# CITY OF PORTLAND, MAINE

April 3, 2017

Project Name: Eleven-Unit Condominium  
Address: 161 York Street  
Applicant: York Street Redevelopment, LLC  
Planner: Shukria Wiar

Project ID: 2016-261  
CBL: 044 B006001

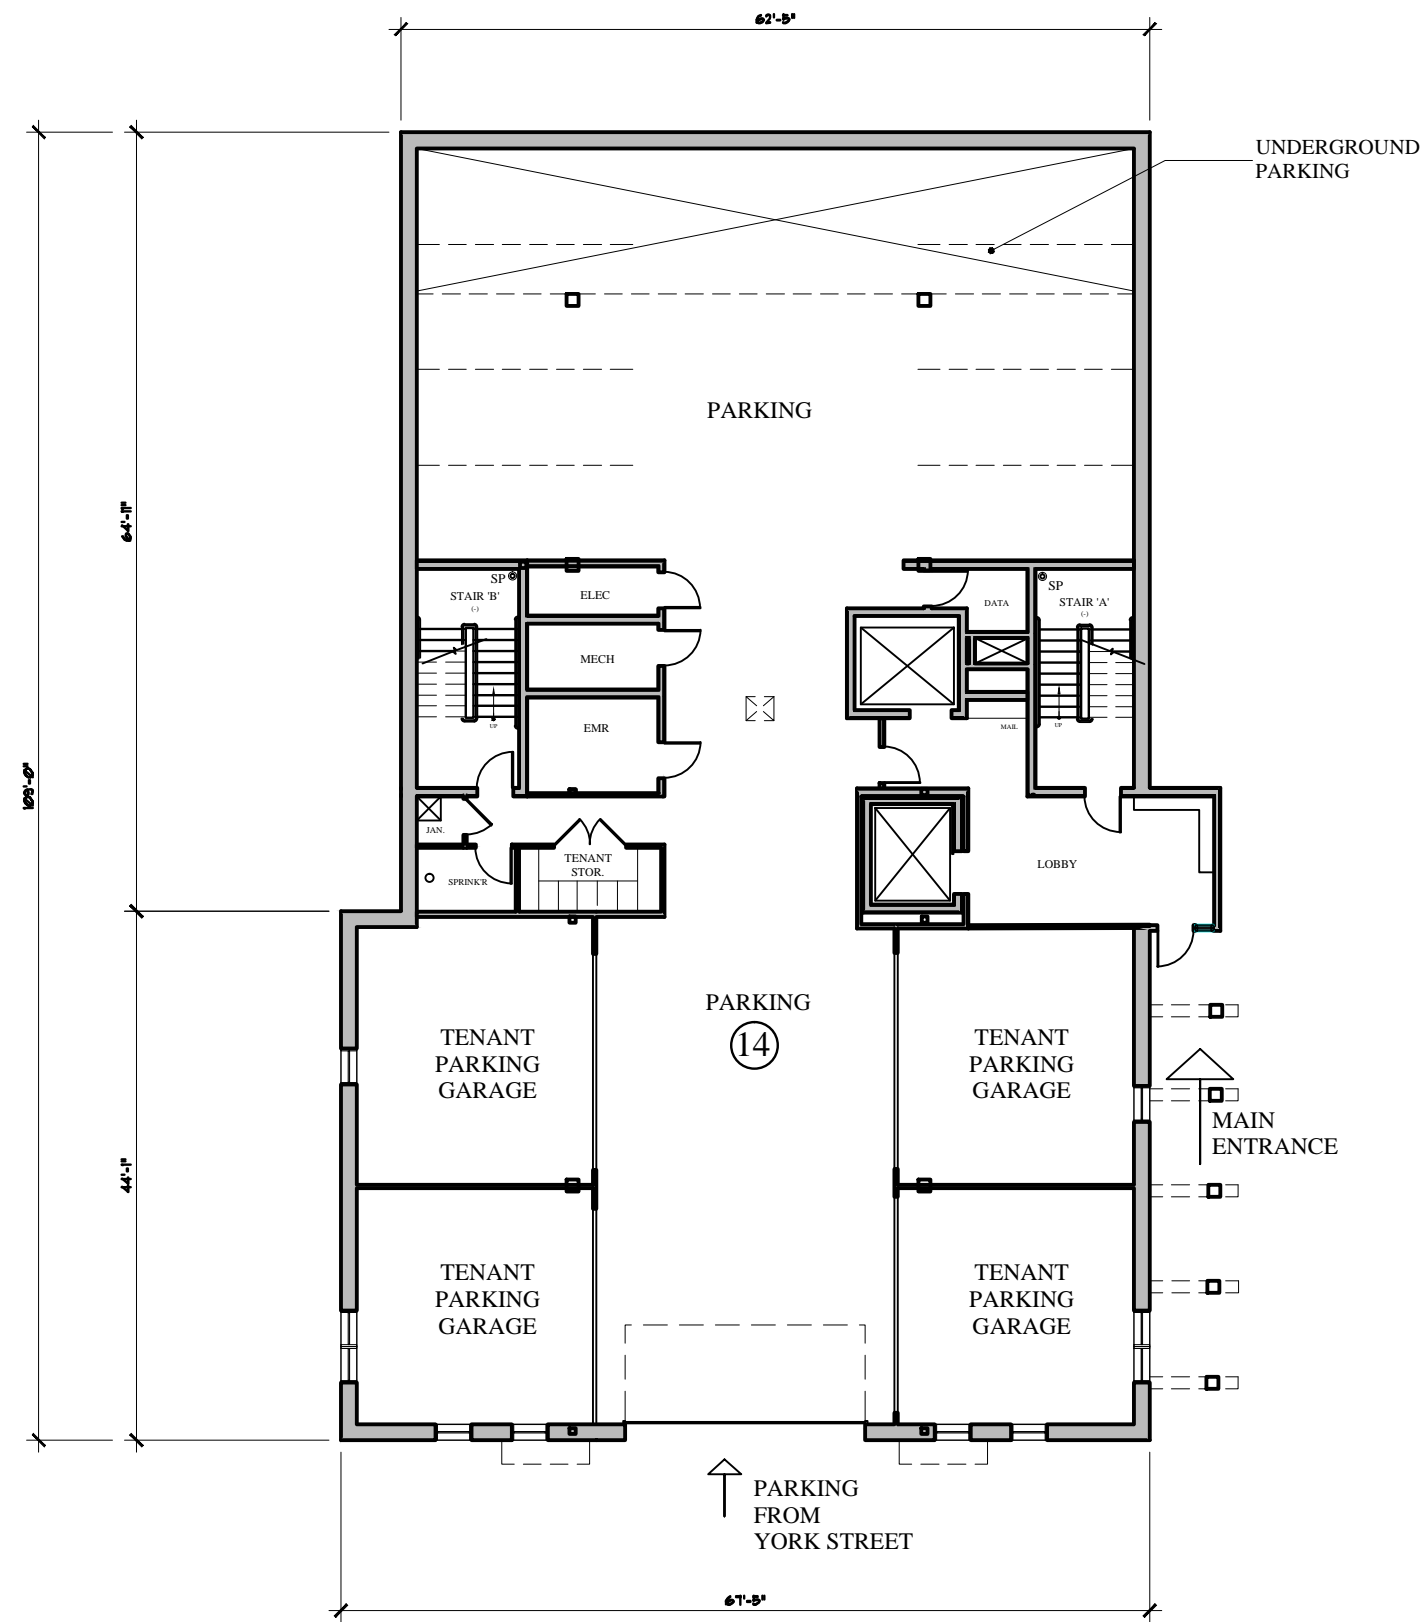
1. The Planning Board voted unanimously (7-0) to waive the *Technical Manual* standard (*Section 1.14*) to allow a 23.39-foot-wide aisle in the lower-level parking garage;

- **Curb Cut on York Street:** The Planning Board and traffic engineer sought eliminate all potential backing maneuvers from York Street due to safety concerns. The Board sought to have the applicant close the existing curb cut on York Street to the east of the site and to reduce the parking spaces on the lower level garage by at least by two spaces to enable vehicles to turn and go forward from the garage;

**Staff Comments:** Two of the parking spaces in the lower level garage have been eliminated, so vehicles can now maneuver within the garage and do not have to back onto York Street. The site plan now shows the curb cut on the east side closed and replaced with brick sidewalk and granite curbing. Tom Errico, Consultant Traffic Engineer has reviewed the revised plans and finds them acceptable.

DRAWING NO.
C-10

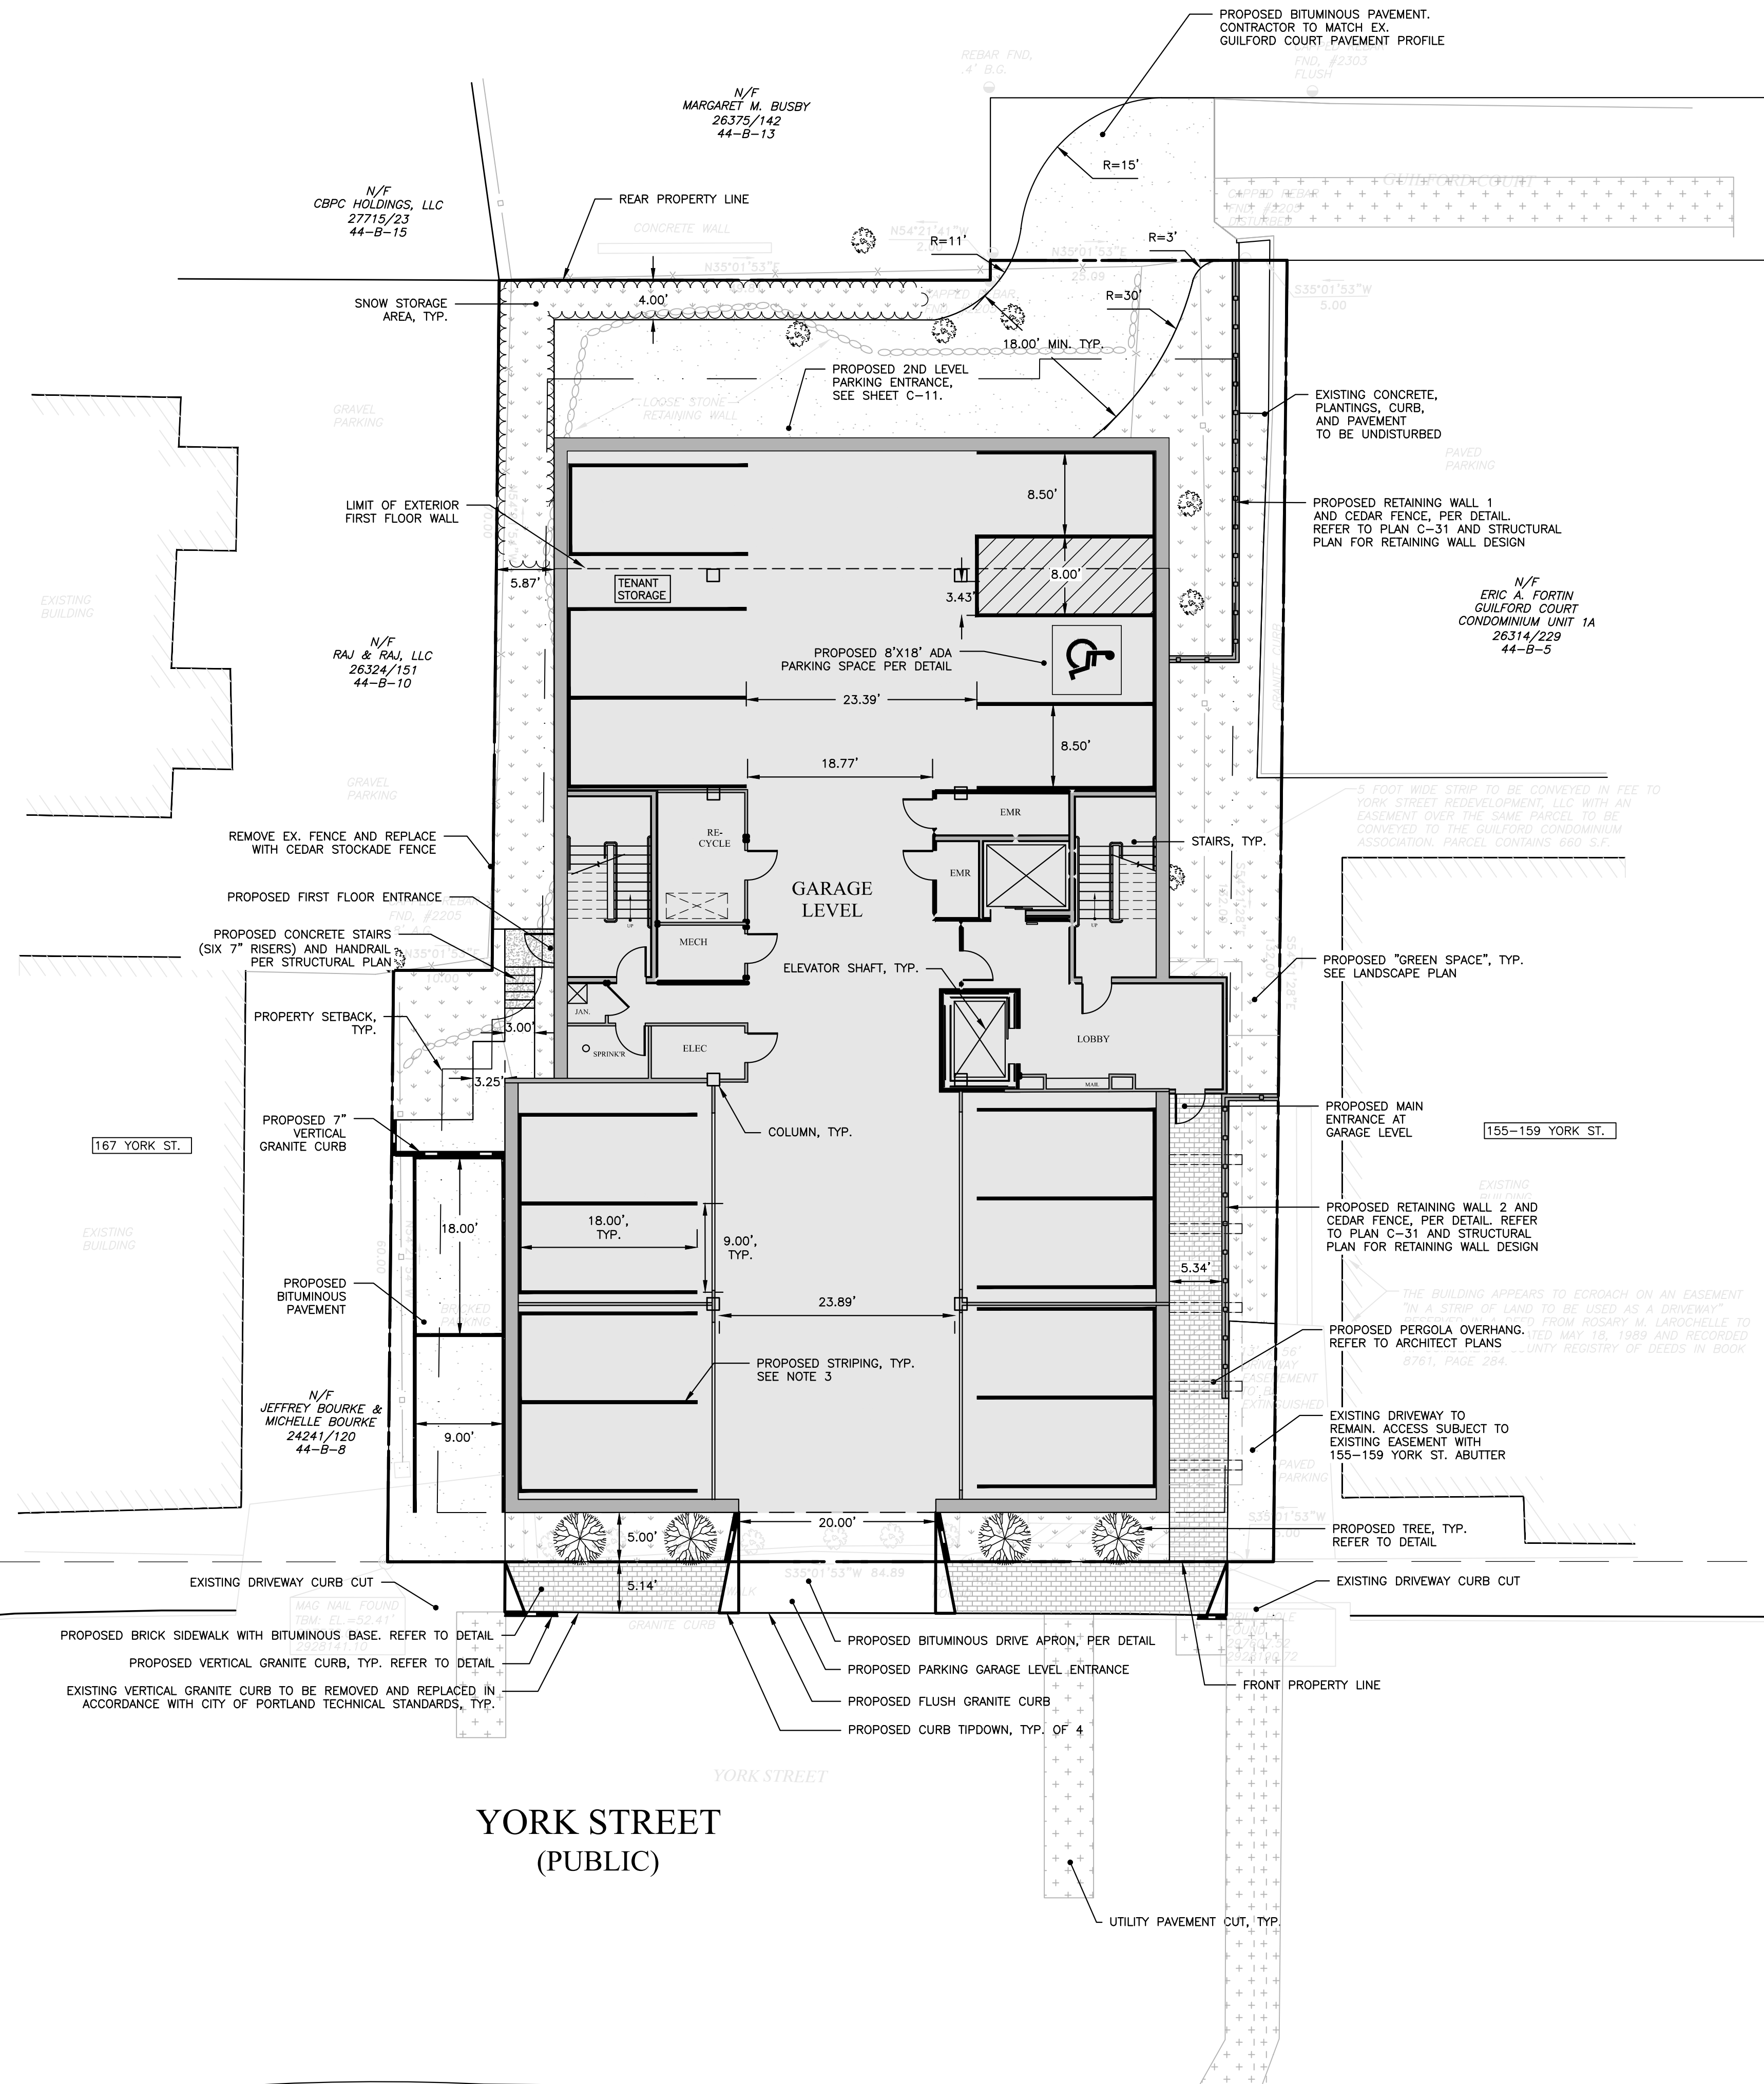
<b>Waiver Requests</b>	<b>Applicable Standards</b>
Drive Aisle width – To allow a 23.39’ foot aisle in the parking area. <u>Staff Comments:</u> The review staff recommends waiving this standard.	Technical Manual, <i>Section 1.14</i> , requiring that aisle width for right-angle parking be 24 feet per Figure I-27
Location and spacing of driveways- To allow driveway spacing of 54 feet.  <u>Staff Comments:</u> Staff supports a waiver for driveway separation between the proposed driveway and the driveway to the west, given site parking characteristics and that backing maneuvers are not required.	Technical Manual <i>Section 1.7.2.7</i> Location and spacing of driveways <i>shall be determined as follows: Along arterial, collector and local streets, minimum acceptable spacing between double or multiple driveways for driveways on adjacent lots or on the same parcel shall meet the criteria of 100 feet for 25 mph</i>
